Parramatta Powerhouse EIS

Flood Risk Review

JULY 2020

Undercroft Space and Flooding

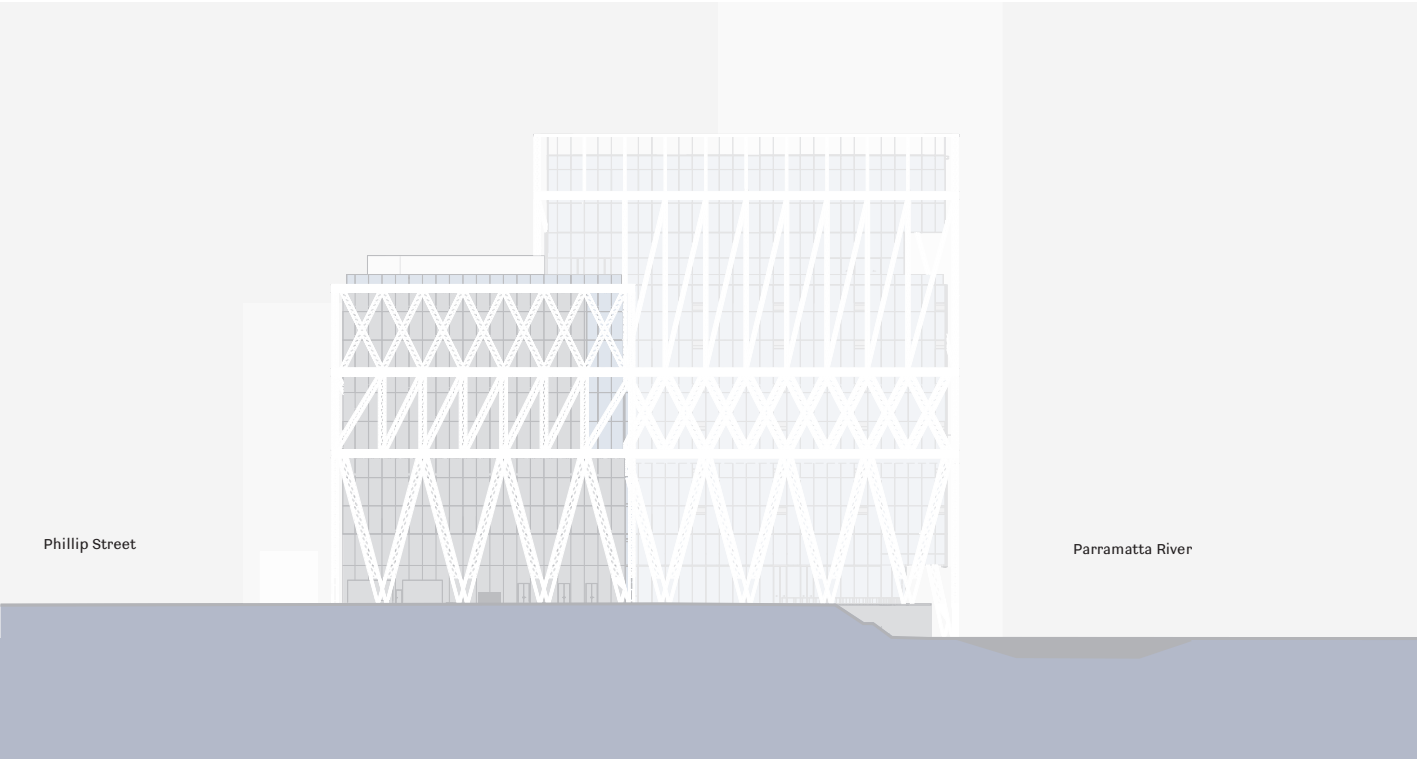
While the undercroft spaces are designed to ensure the development does not increase flood levels in the Parramatta River in the 1% AEP flood, they may present a serious flood risk to life.

It is quite reasonable to expect that during inclement weather, museum patrons, or more likely, members of the public could take shelter in the undercroft areas. However, as shown in Figure 9, there are two problems in leaving these shelters once flooding commences.

The first is that it is necessary to walk down towards the river before being able to walk up to flood free ground.

The second is that the routes up are designed as overland flow paths.

People sheltering within these spaces may not appreciate just how high and how quickly the river can rise and they become entrapments in which people drown or they drown trying to leave them.
